CITY OF PORTLAND

BUILDING PERMIT

Job ID: 2011-11-2719-ALTR

has permission to 6' x 24' Addition

**OVERALL SITE PLAN
PROPOSED PORCH**
FOR MATTHEW EK & CANDACE ANDERSON-EK
424 AUBURN STREET, PORTLAND, ME 04103

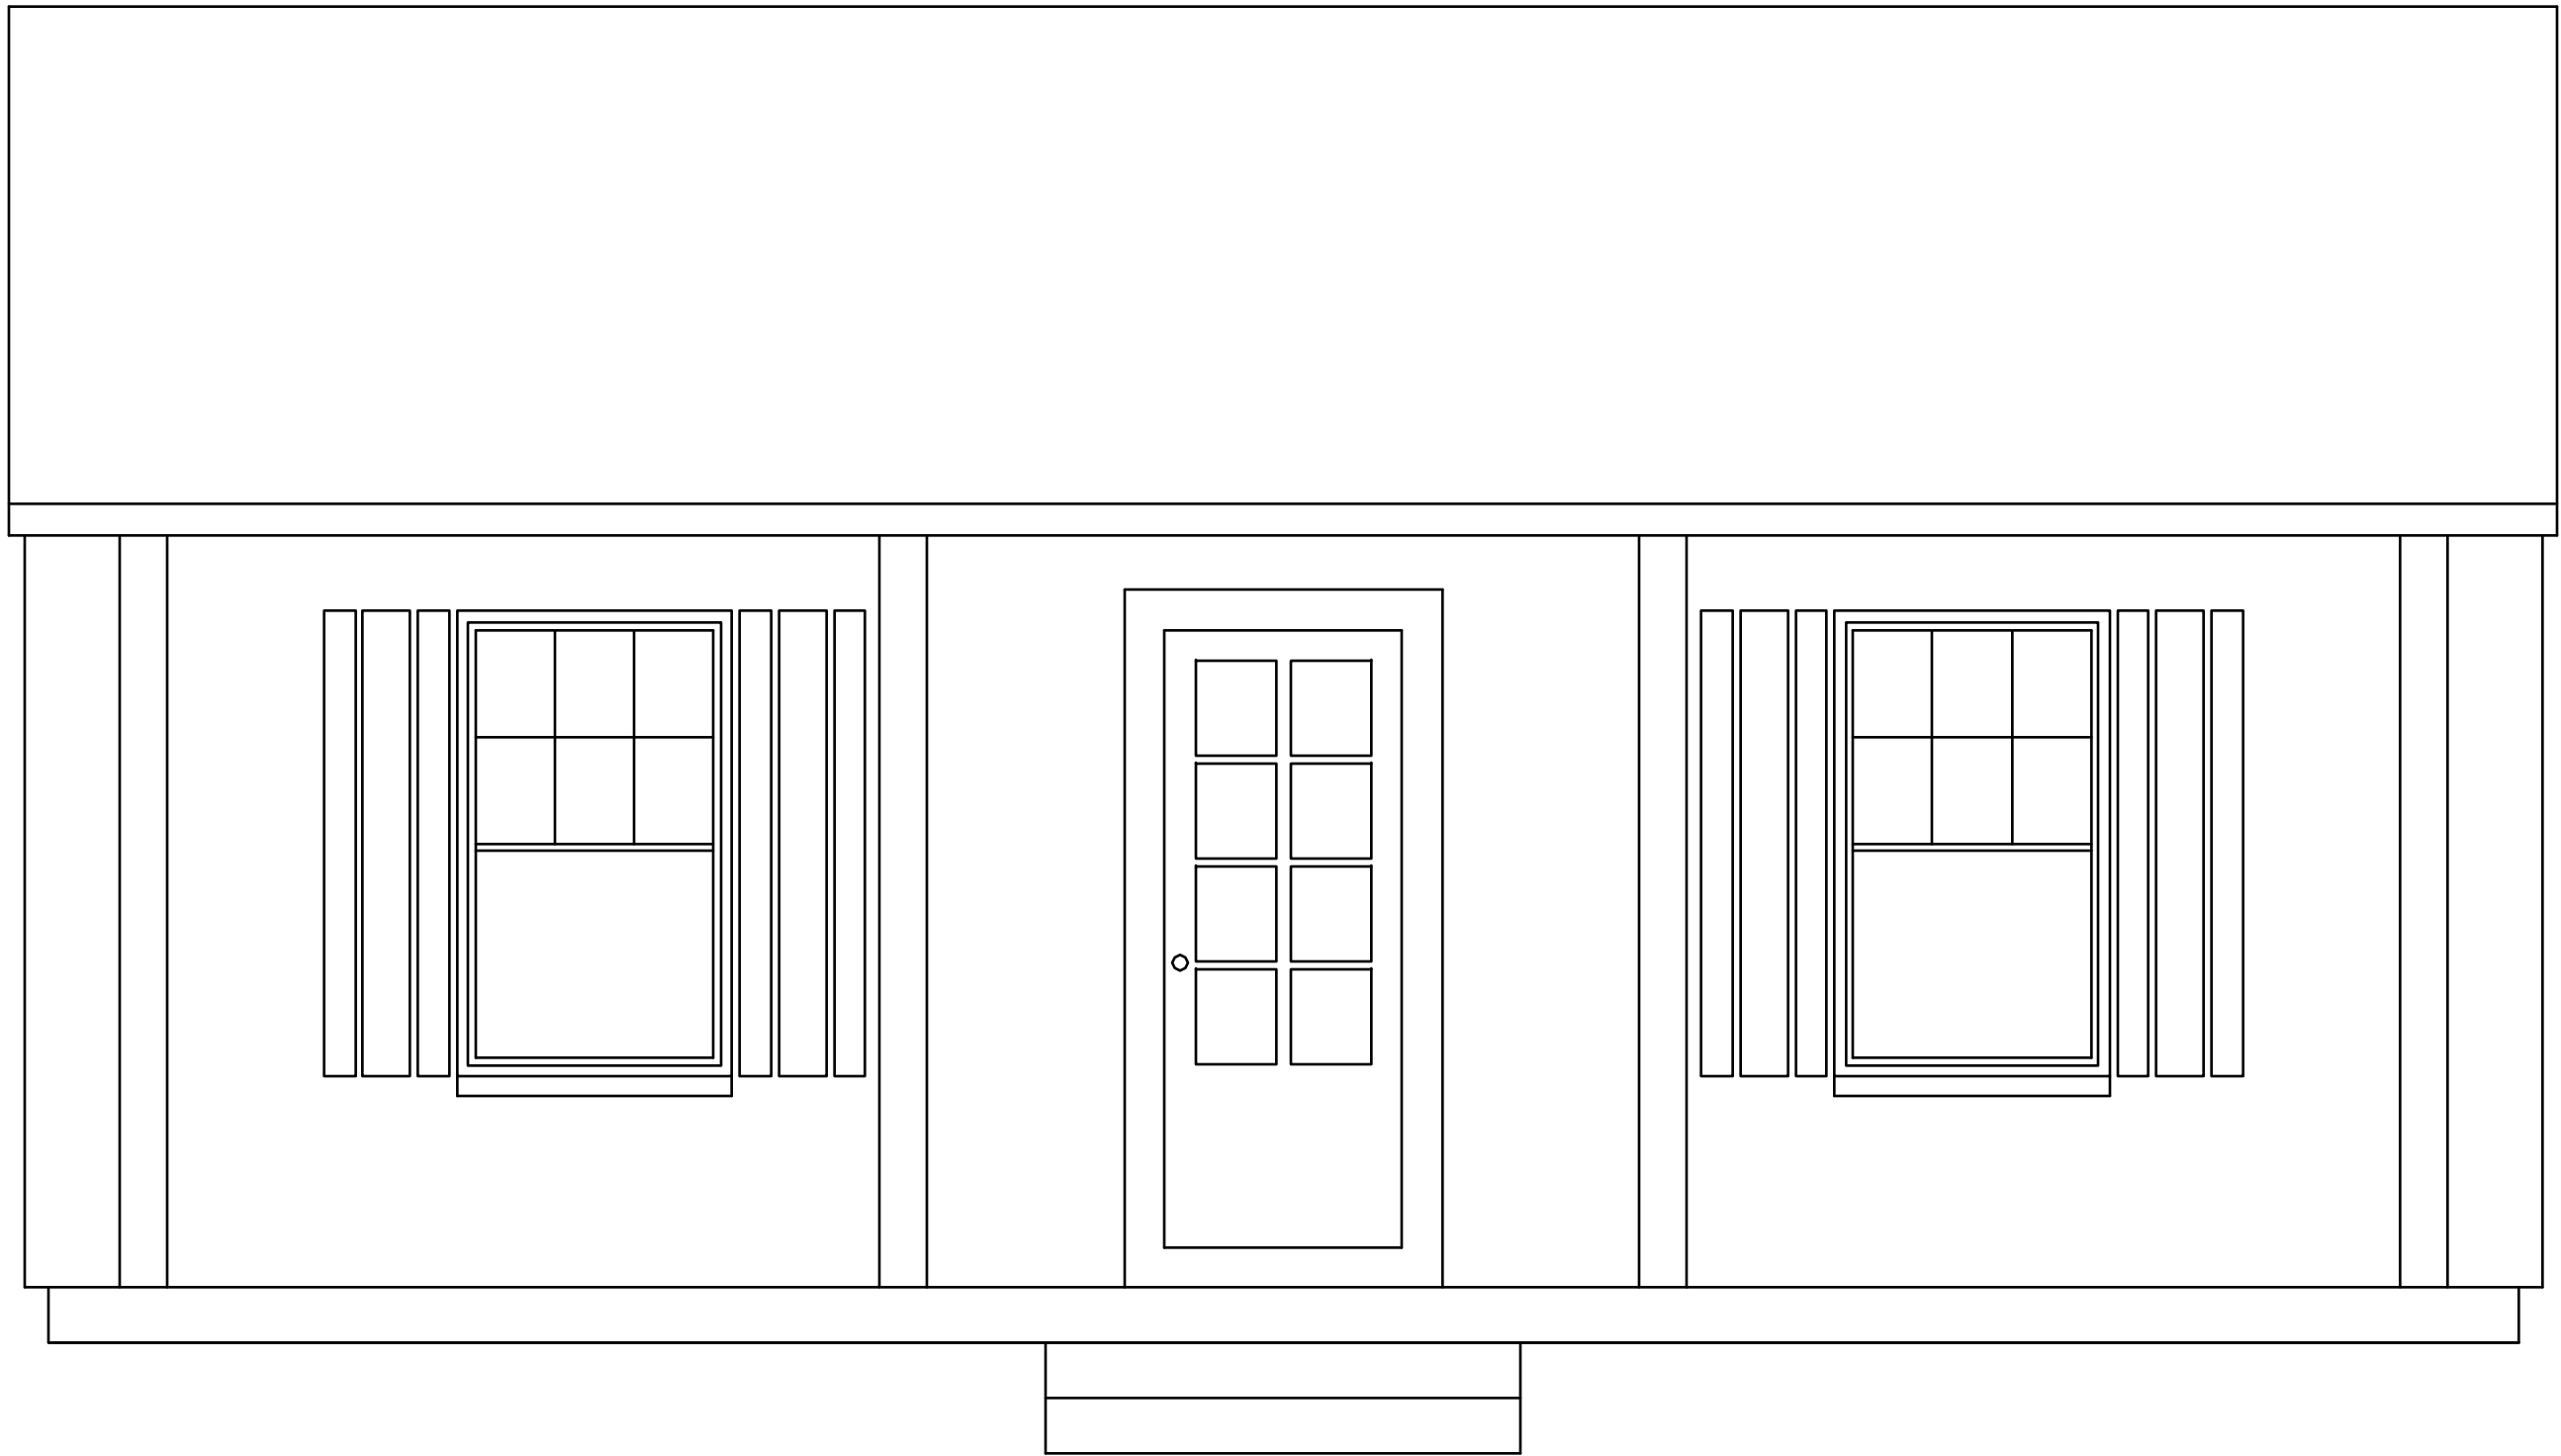
front 23.5' Allowed under
14-425 - ok
Per R: 25' - 25' + 5' low
side: 8' min - well over 8'

AREA OF PORCH ENCRANCHING INTO SETBACK IS 39 S.F. (WHICH IS LESS THAN THE 50 S.F. ALLOWED UNDER SECTION ~~1A-125~~ OF THE CITY ORDINANCE) *Plus*

2 PROPOSED GRANITE STEPS 5' WIDE
considered landscaping - not constructed

**CROSS SECTION
 PROPOSED PORCH**
 FOR MATTHEW EK & CANDACE ANDERSON-EK
 424 AUBURN STREET, PORTLAND, ME 04103

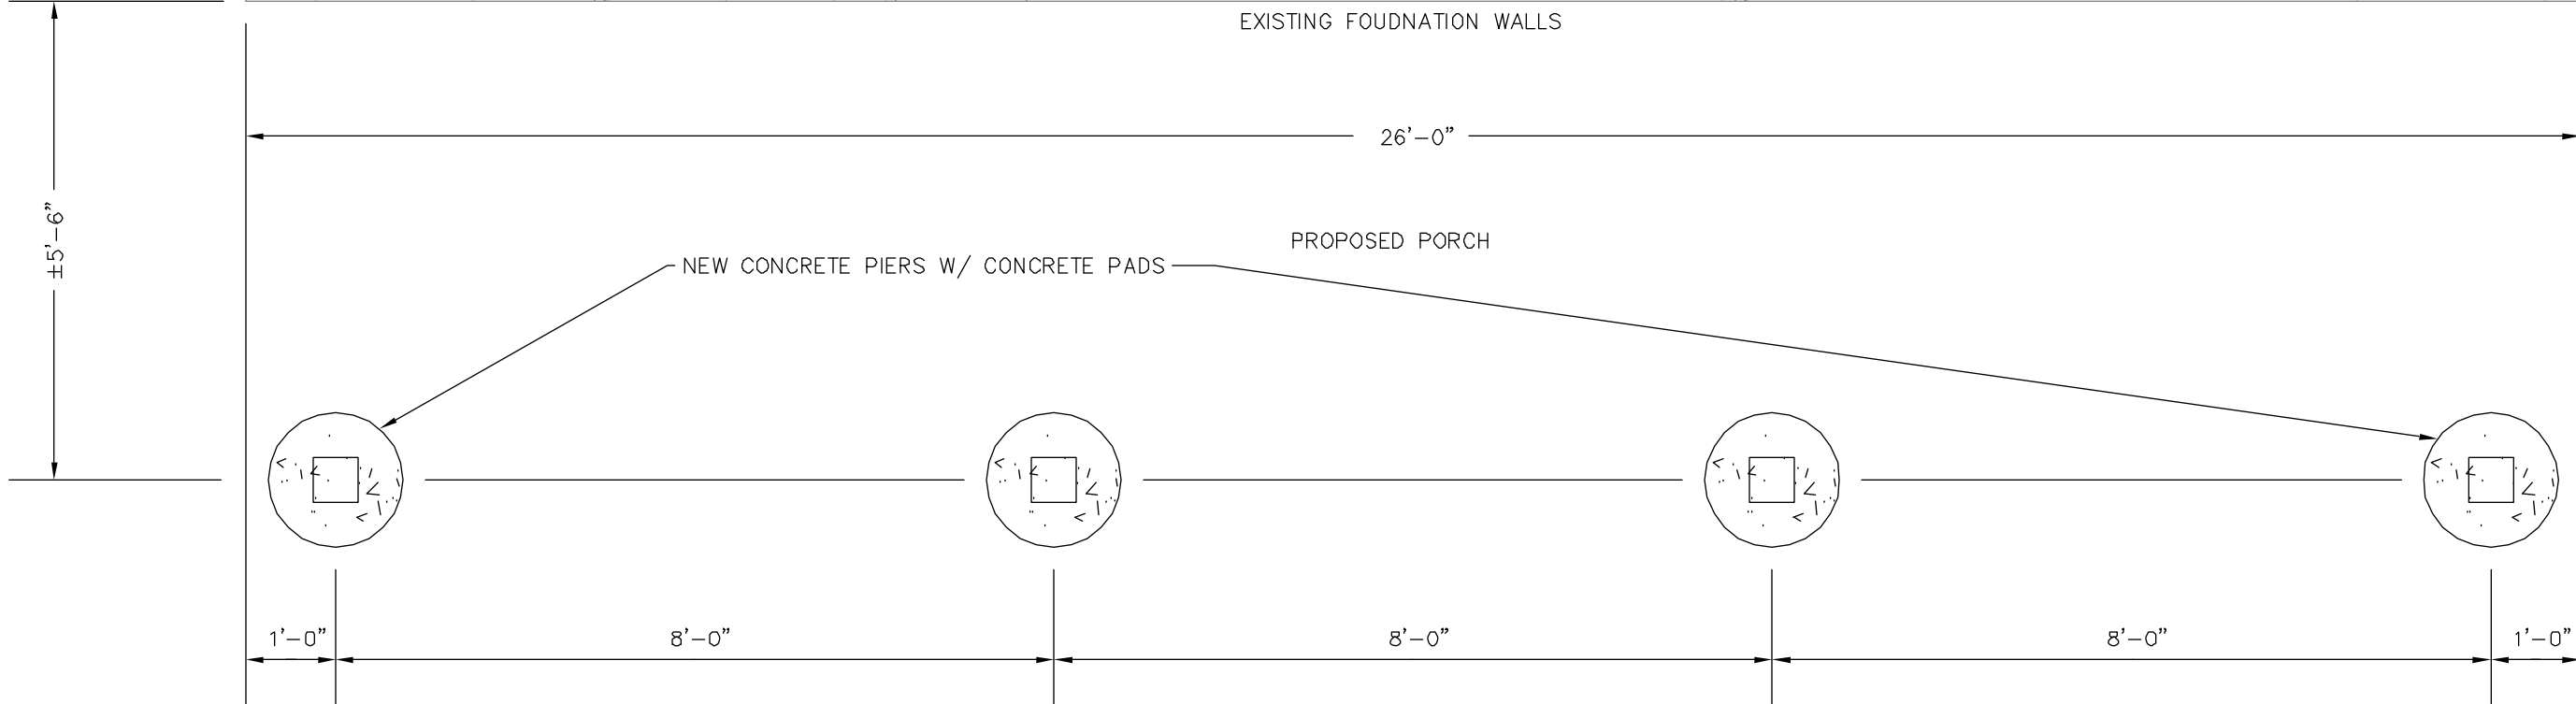
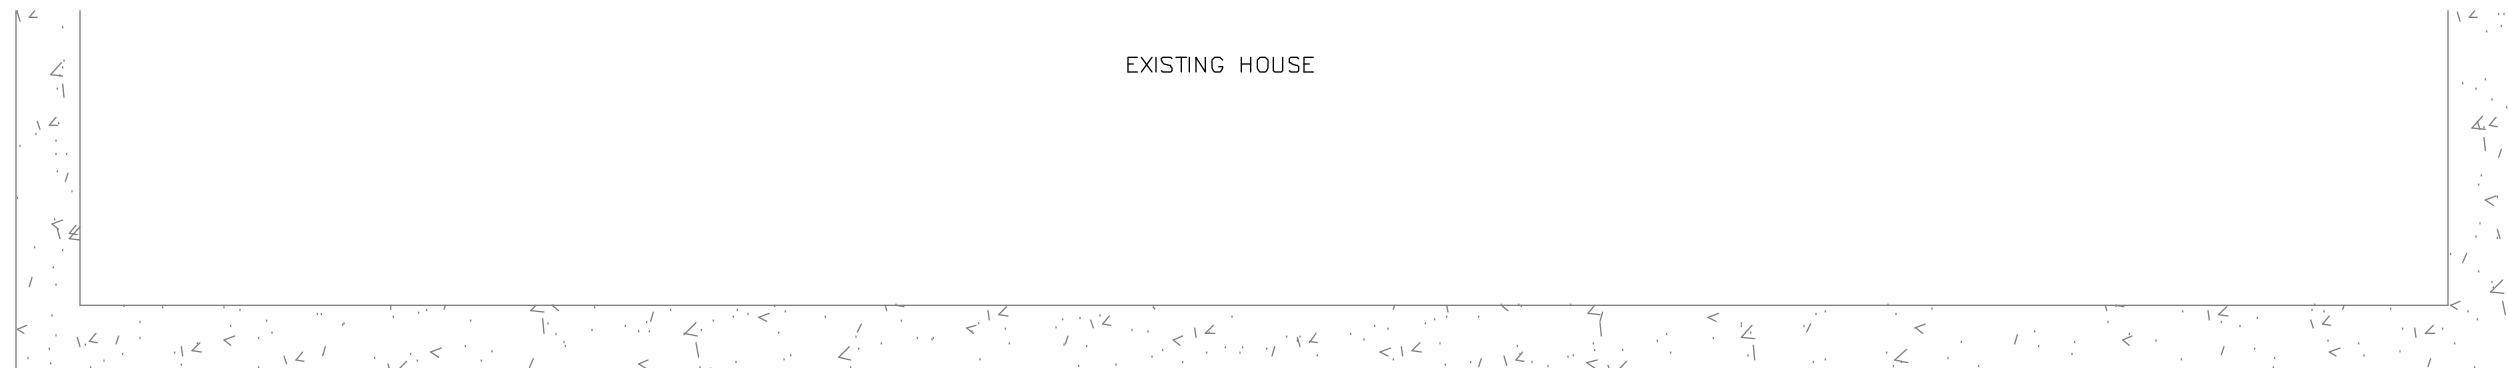
*Per conversation with Builder
 3 2"x8" Piers and in line with upper beam
 all 2"x8" Joists will be Joist
 Hungered into bottom beam
 MJA*

*No Railings needed if
 Deck is Below 30"*
